Erection of 1 no. dwelling
312 Chichester Road Bersted

Thank you for your internet representation made on 7th January 2019 which has been recorded as '**an objection**' with the comments as follows:

Ref: Application: BE/102/18/PL - 312 Chichester Road. Bersted. PO21 5AU

| PROJECT TITLE                                                  |  | DRAWING TITLE                  |                         | No | REVISION | DATE |
|----------------------------------------------------------------|--|--------------------------------|-------------------------|----|----------|------|
|                                                                |  | DRAWN BY<br>AP                 | DRAWING No<br>PA-276-05 |    |          |      |

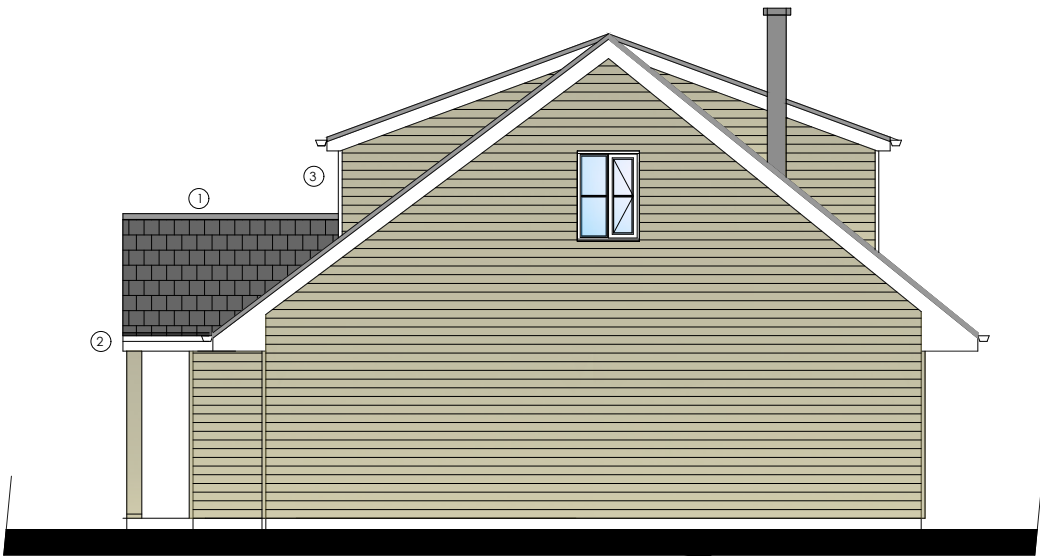
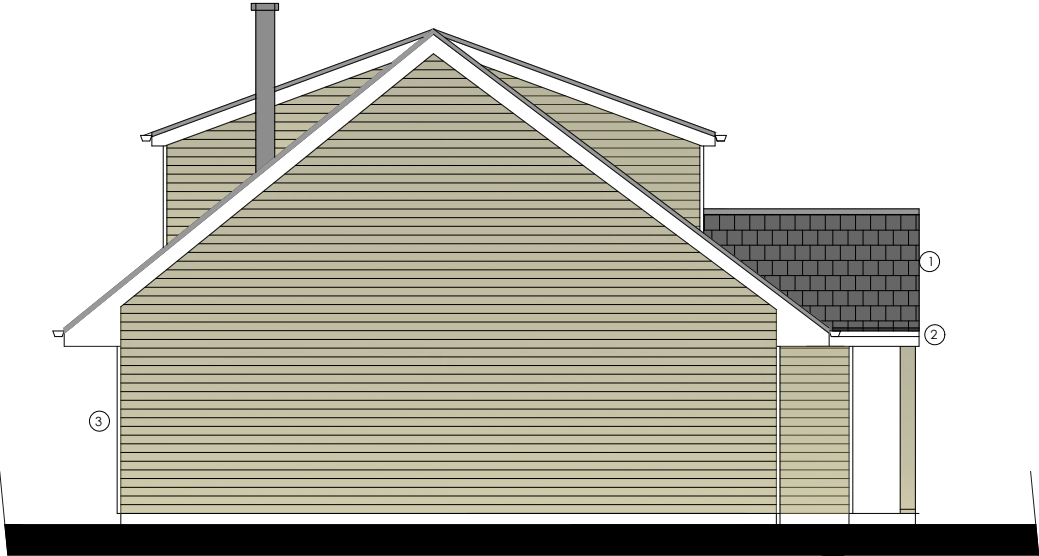
3.0 The drawings in plan - Proposed Location PA276.04 show the property being located towards the rear of the garden with the rear walls some 10 metres from the rear property boundary with mine. 3.1 Drawing PA276.04 also shows bedroom 1 to the rear with drawing PA276.05 - Elevations clearly illustrating the size of the window. This proposal clearly provides an overlooking aspect to my property which is contrary to planning criteria
